Longfield Solar Farm

Applicant Responses to ExA Further Written Questions

Document Reference : EN010118/EX/8.15(A)

Deadline 6

**KEY**

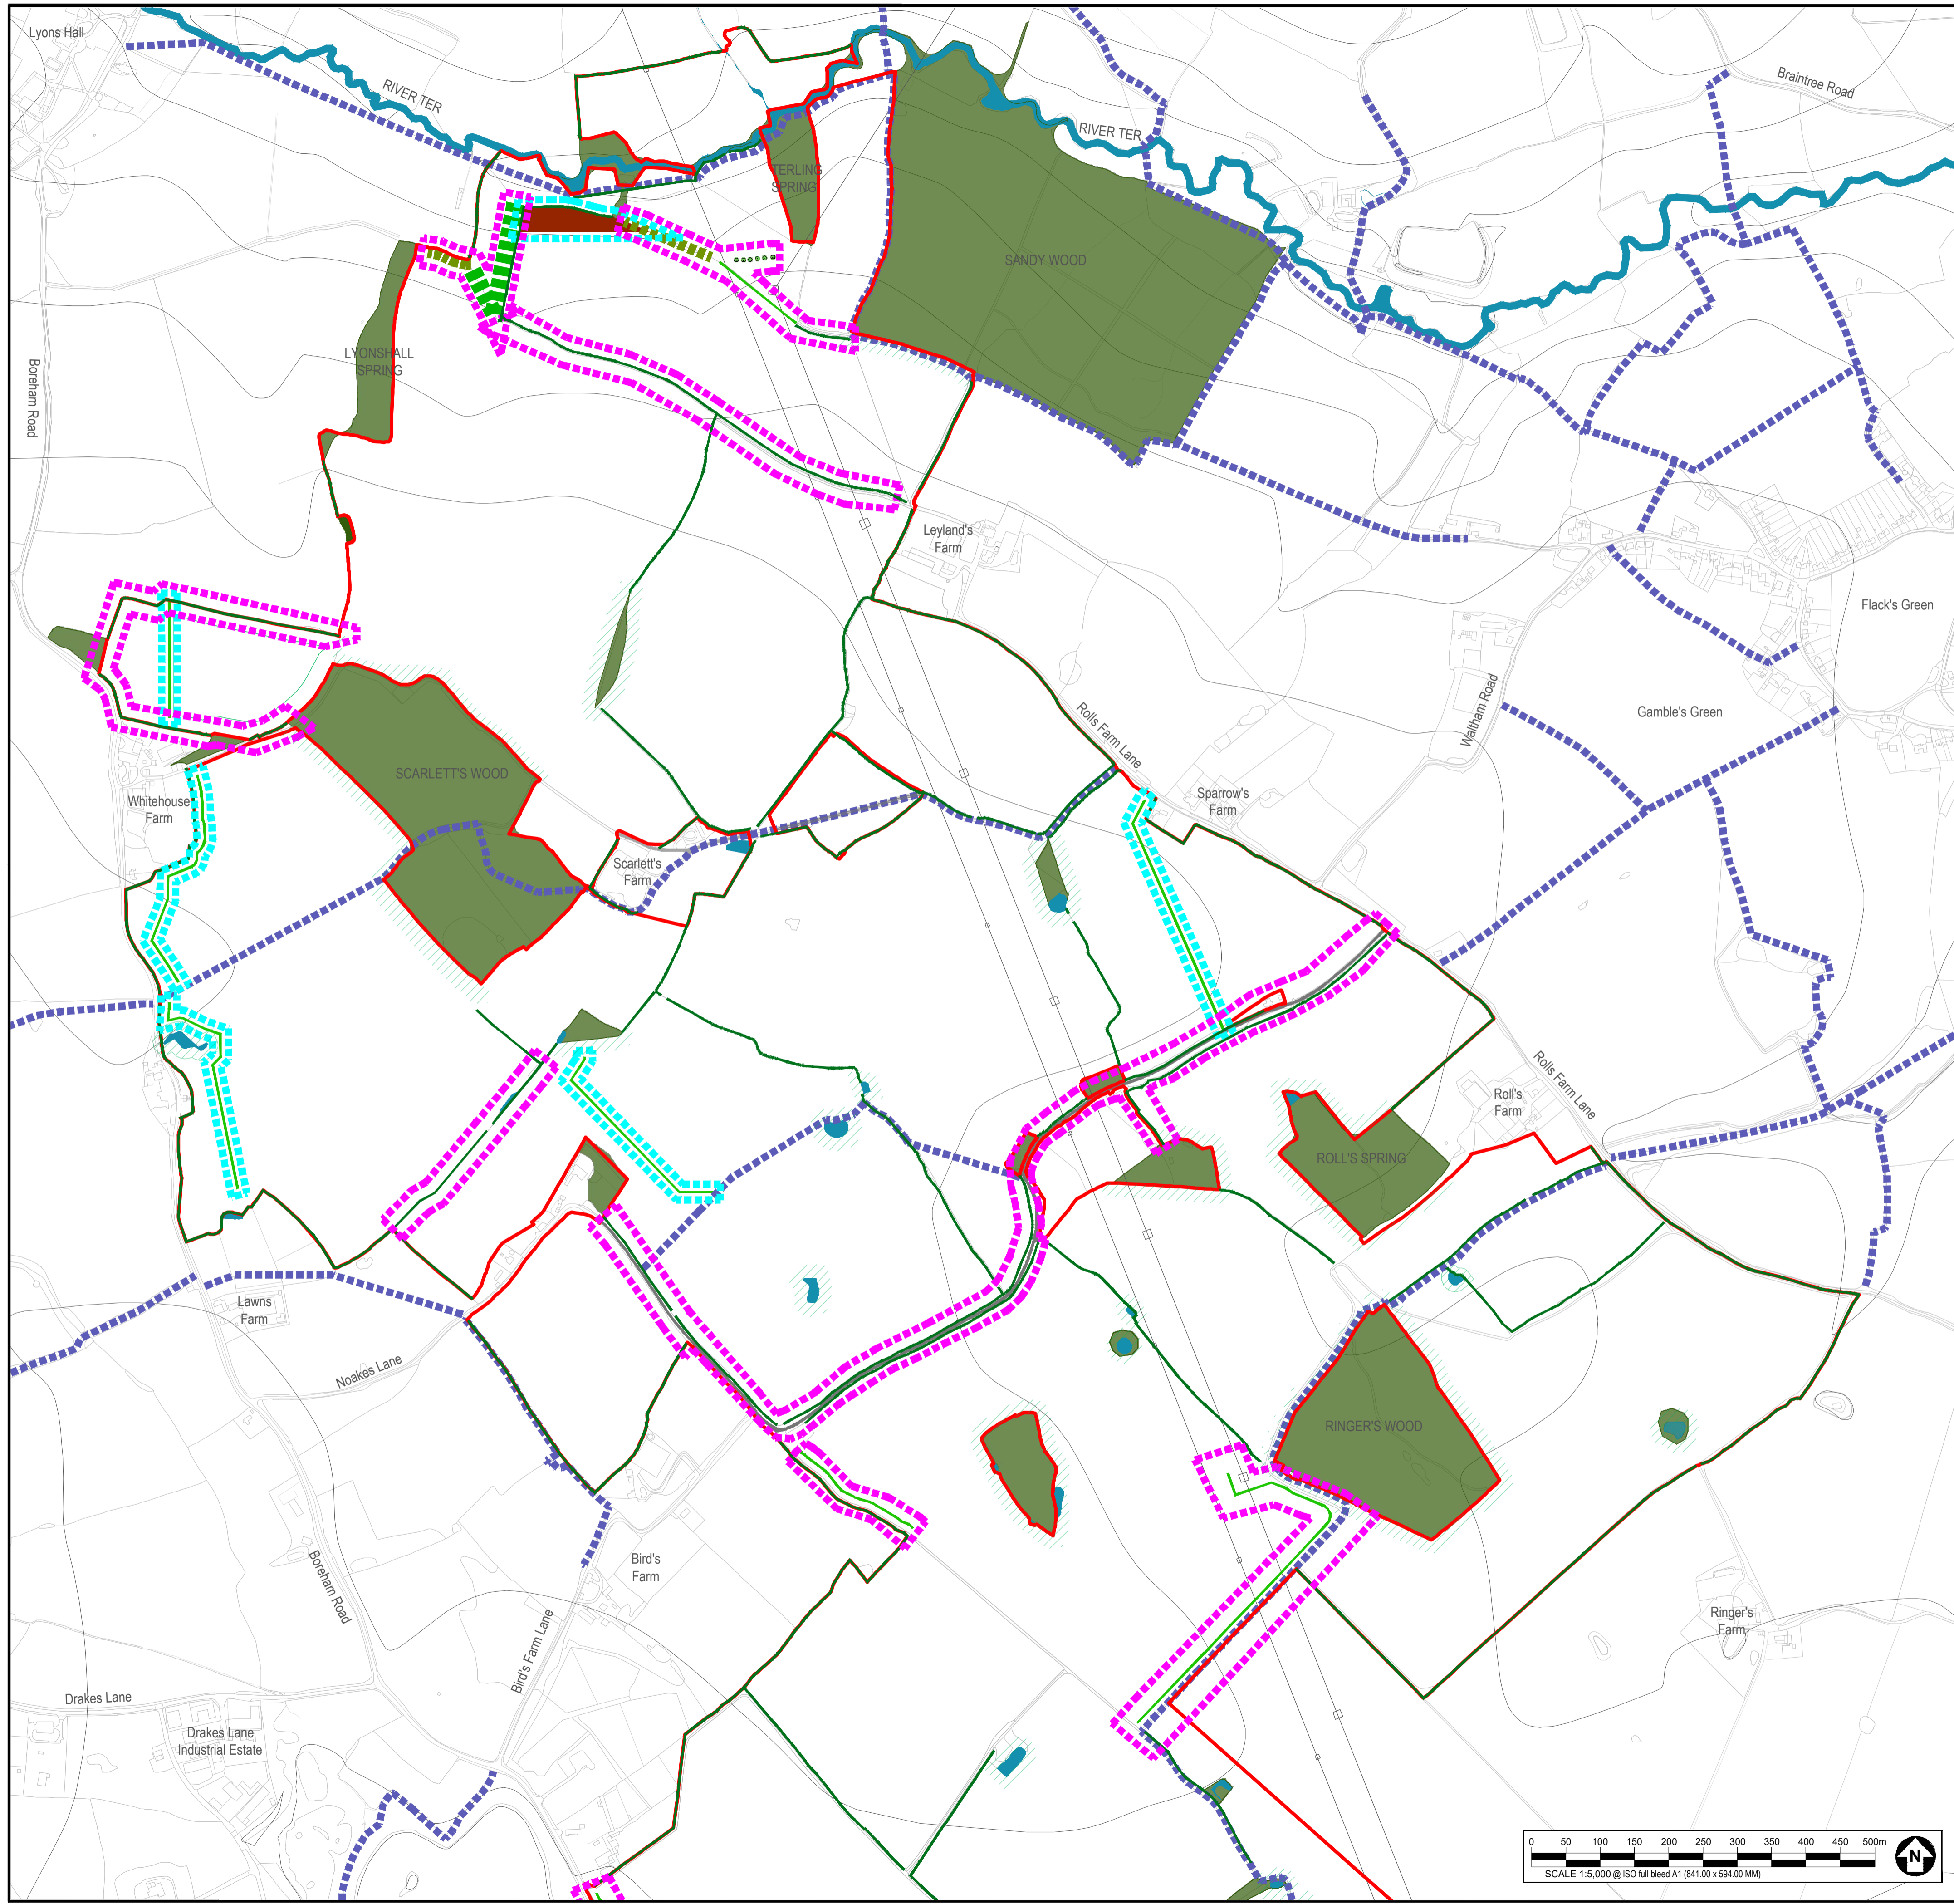
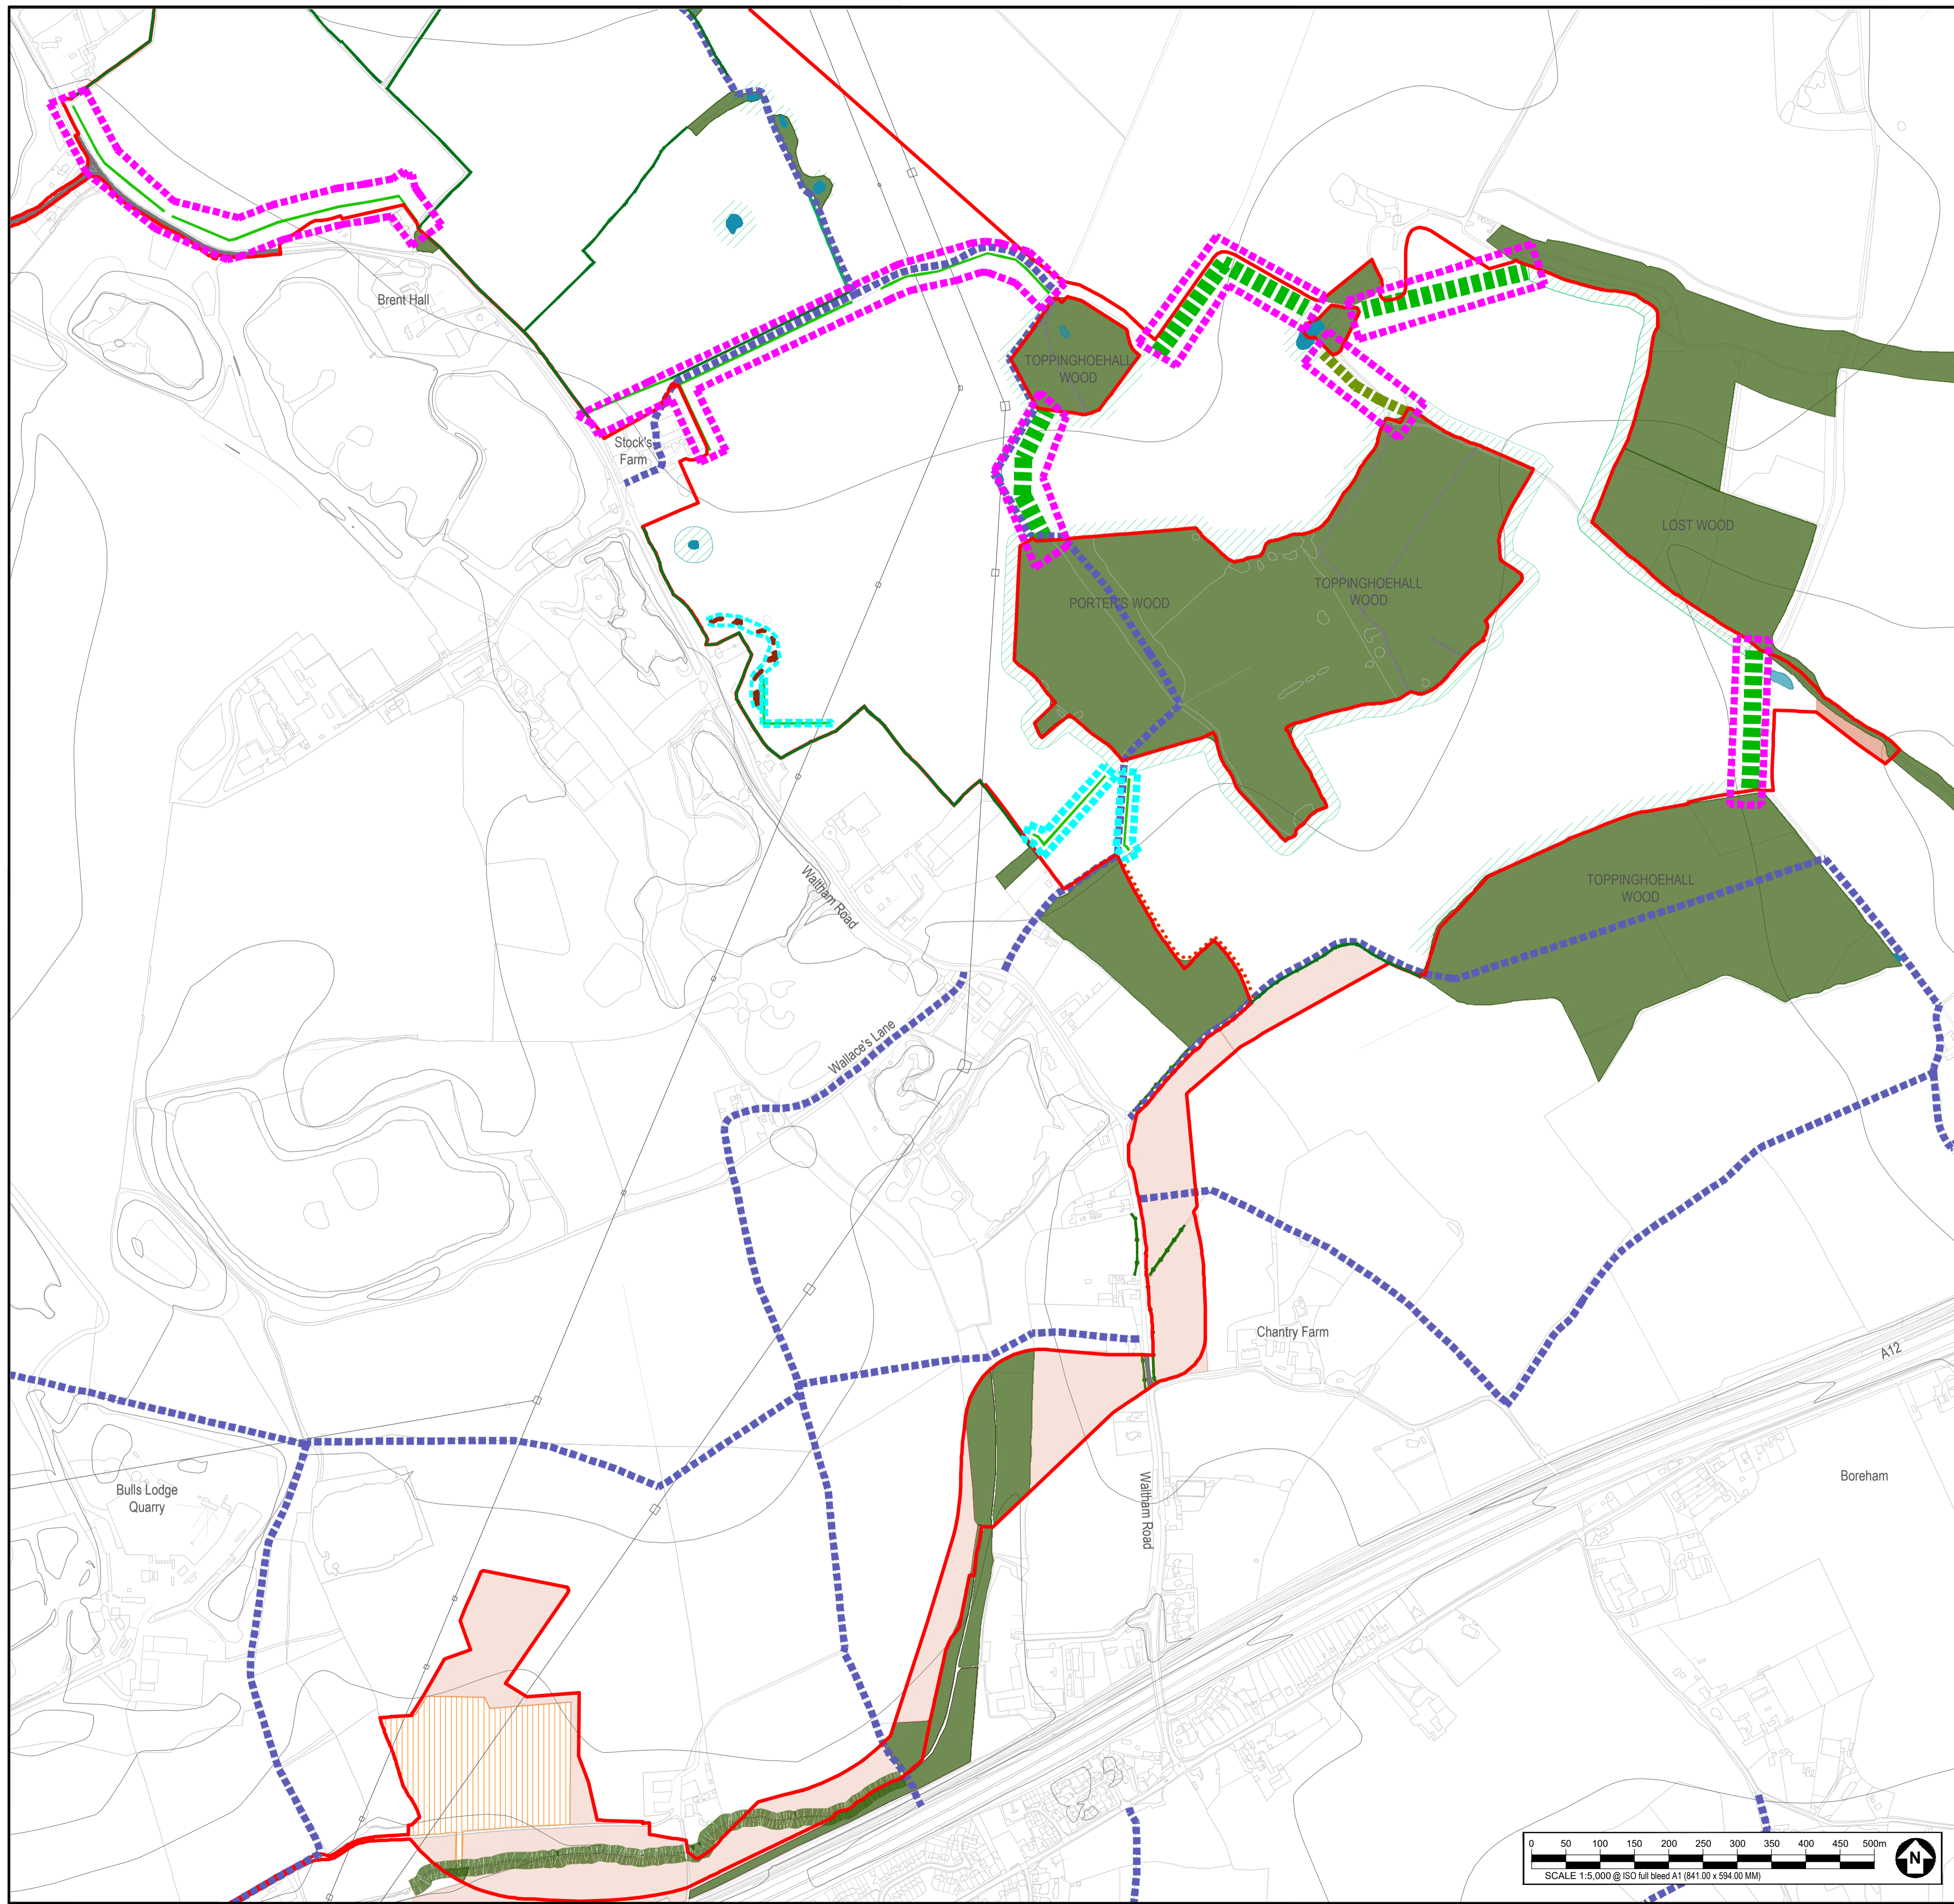
<p>3.2.8</p>	<p>Applicant</p>	<p>The ExA notes that the oLEMP submitted at Deadline 5 [REP5-006] does not include Annex A. Please provide a complete and fully consolidated version of the oLEMP.</p>	<p>This error has been <u>corrected</u> in the document and submitted at Deadline 6.</p>

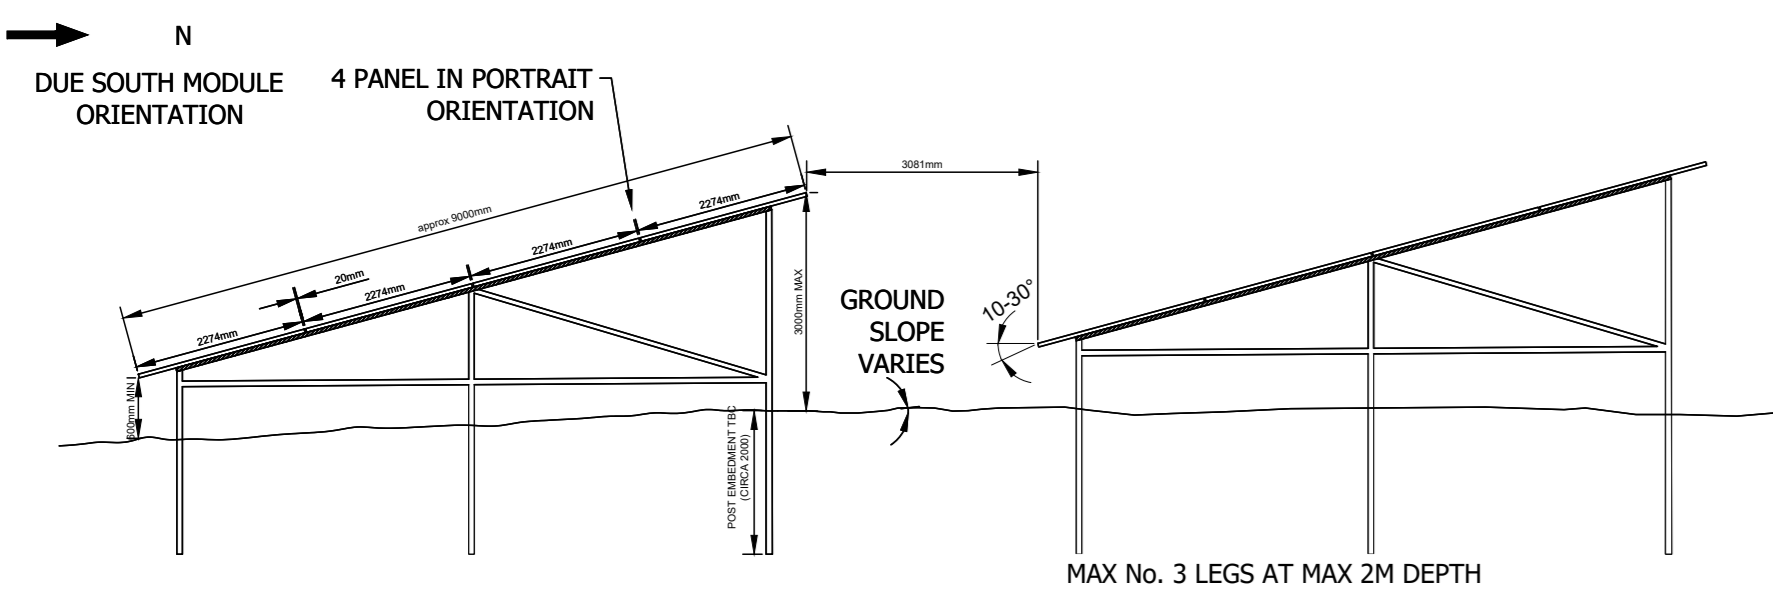
3.2.4	Applicant	The ExA notes that the 'Legend' contained in the Illustrative Concept Design [REP3-041] contains an error in relation to the identification of individual trees (the green colouring appears to have been deleted). Please review and provide an updated document into the Examination.	This error has been corrected in the document and submitted at Deadline 6 (ES Figure 2-27 Construction Layout, [APP-132] and ES Figure 2-5 Illustrative Concept Design, [APP-110] .
